Re: Sapphire Solar Farm Environmental Impact Statement

Enclosure: Attachment 1: Detailed OEH Comments – Sapphire Solar Farm EIS

Figure 7-1: Vegetation Zones

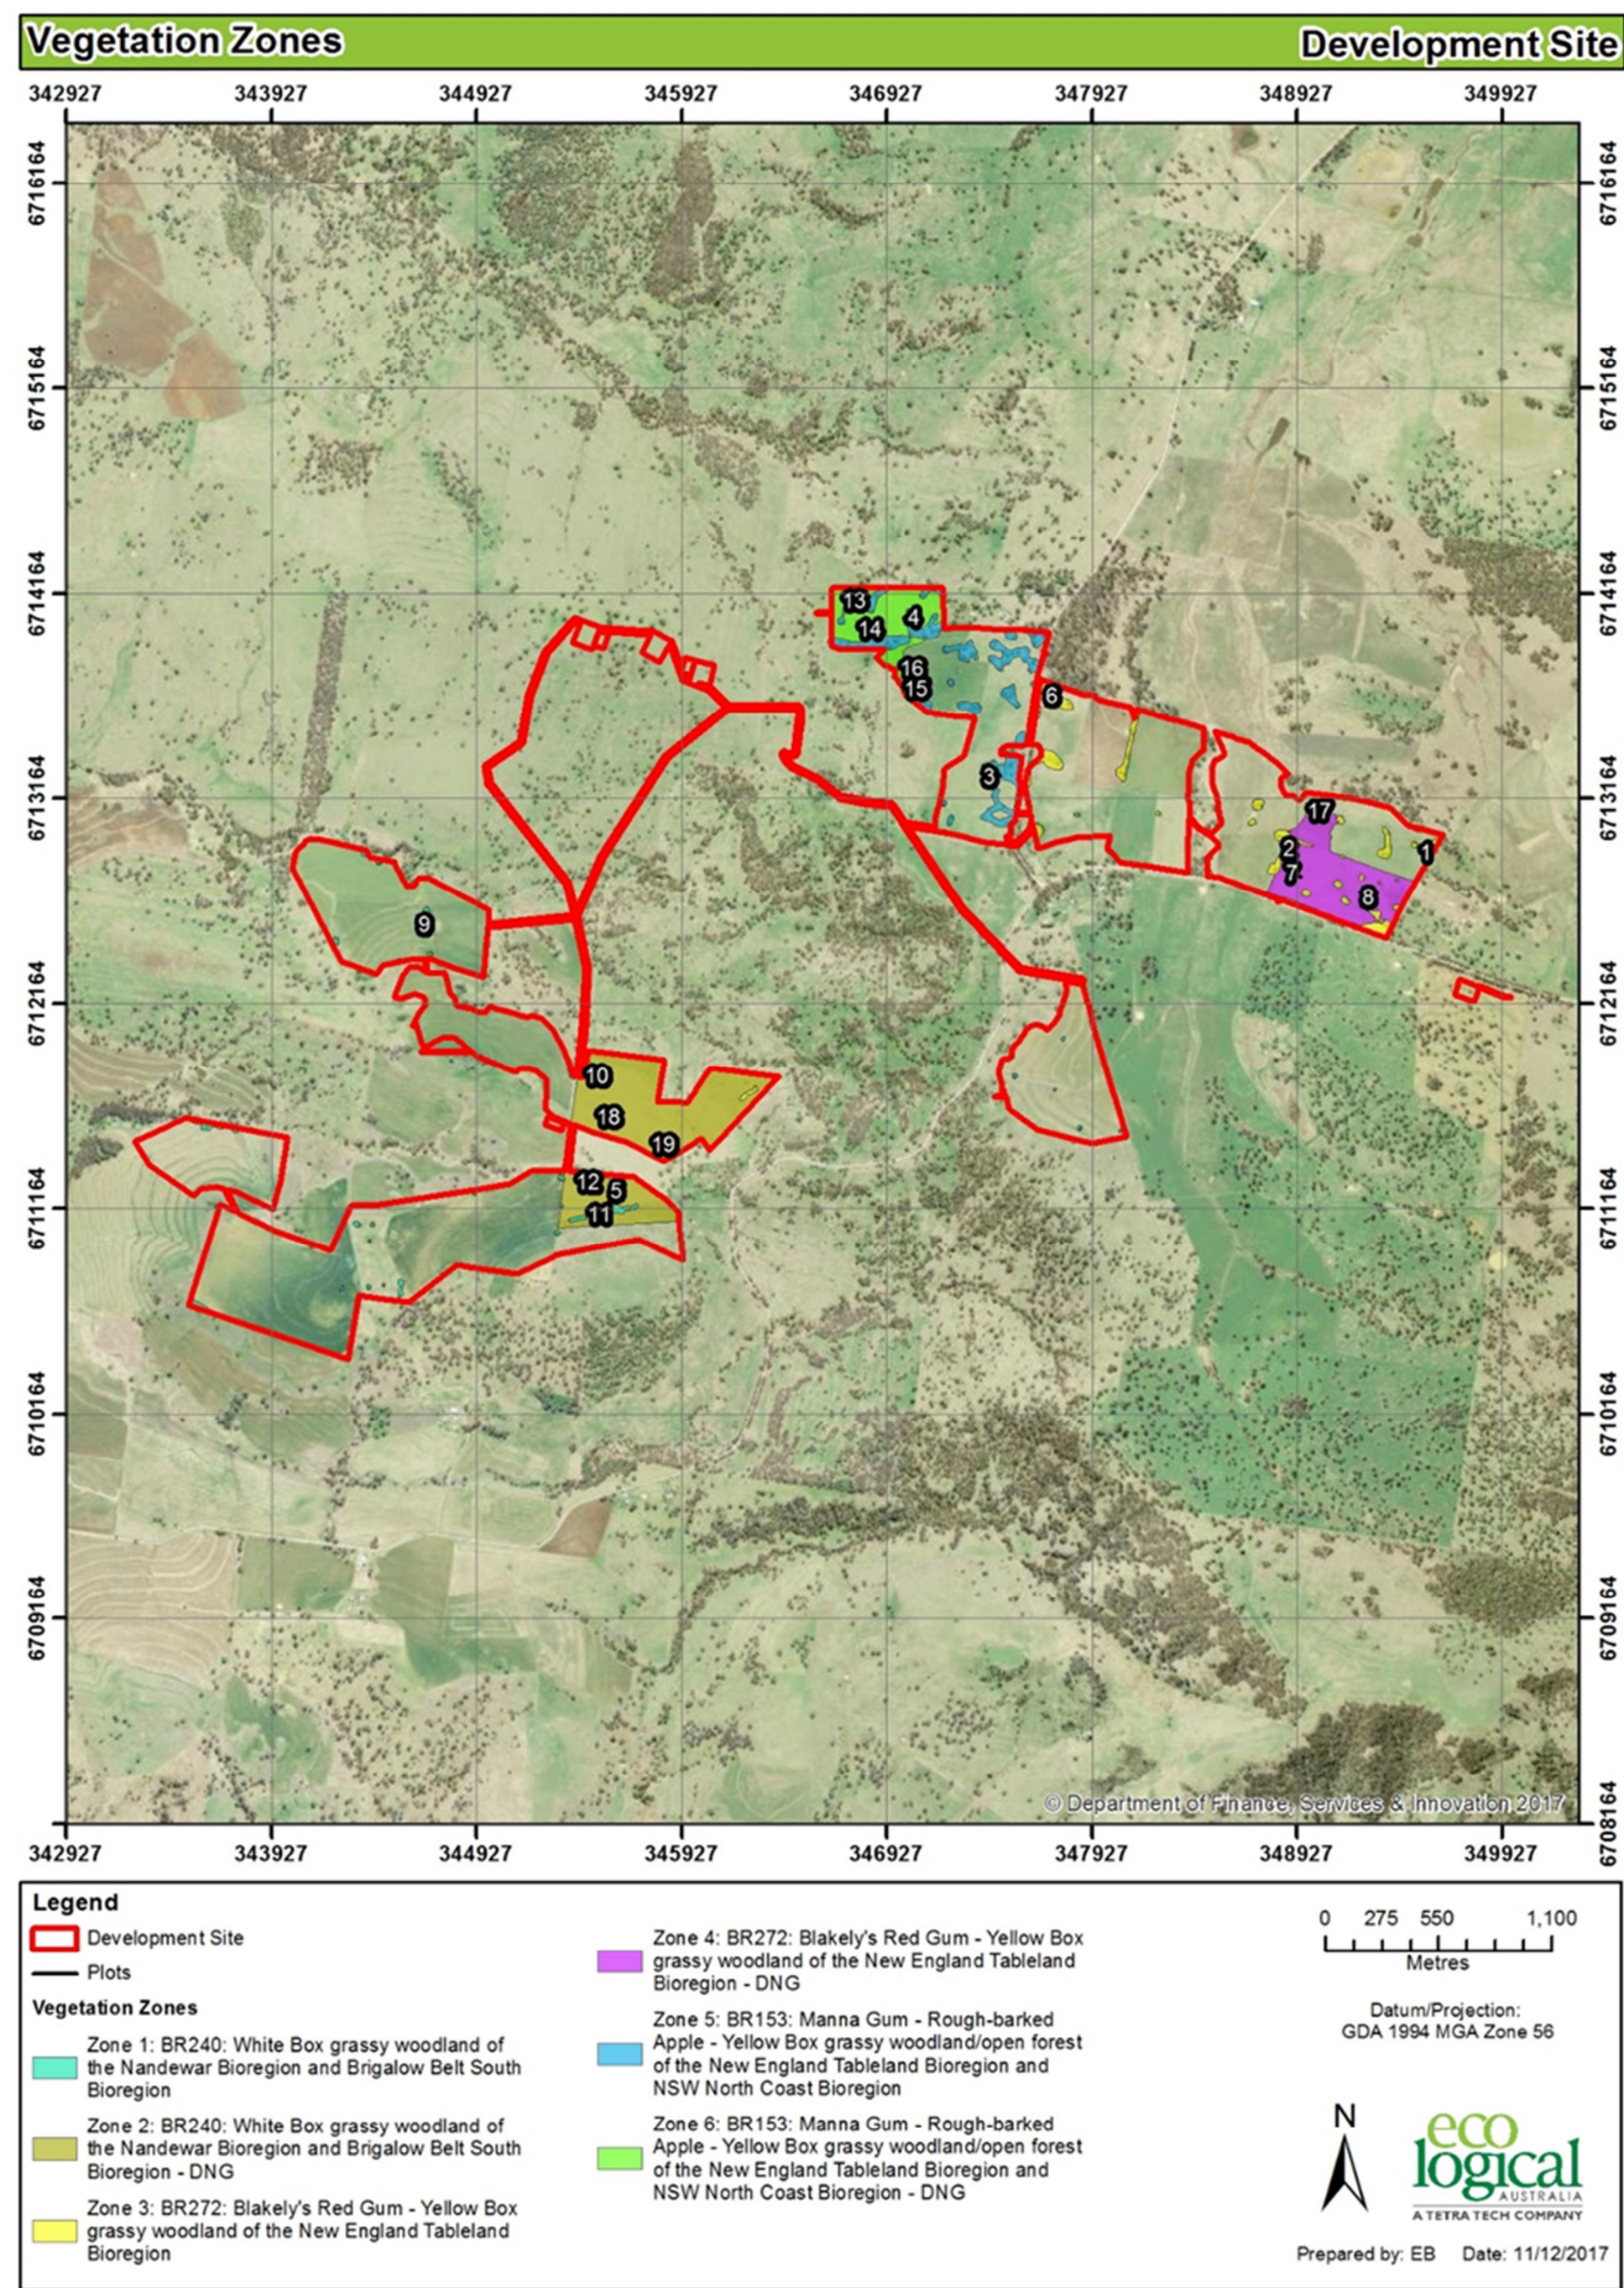
1. Amend Figure 6 of the Biodiversity Assessment Report (BAR) to clearly illustrate the location and extent of the vegetation zones in all areas within the development site, including the proposed cable routes.

Figure 7 of the Biodiversity Assessment Report (BAR) appears to illustrate several patches of white box – yellow box – Blakely's red gum woodland Endangered Ecological Community (EEC) within the proposed cable route options. However, these EEC patches do not appear to have been included in the vegetation zones identified in Figure 6 of the BAR.

1. Amend Figure 6 of the BAR to clearly illustrate the location and extent of the vegetation zones in all areas within the development site, including the proposed cable routes.
2. Amend Stage 2 of the BAR to clarify whether the estimated removal of 104.1 ha of the Endangered Ecological Community (EEC) white box – yellow box – Blakely's red gum woodland has included clearing of EEC remnants within the proposed cable routes and, if necessary, revise the EEC removal estimate and associated credit requirements to address clearing impacts for all components of the proposal.
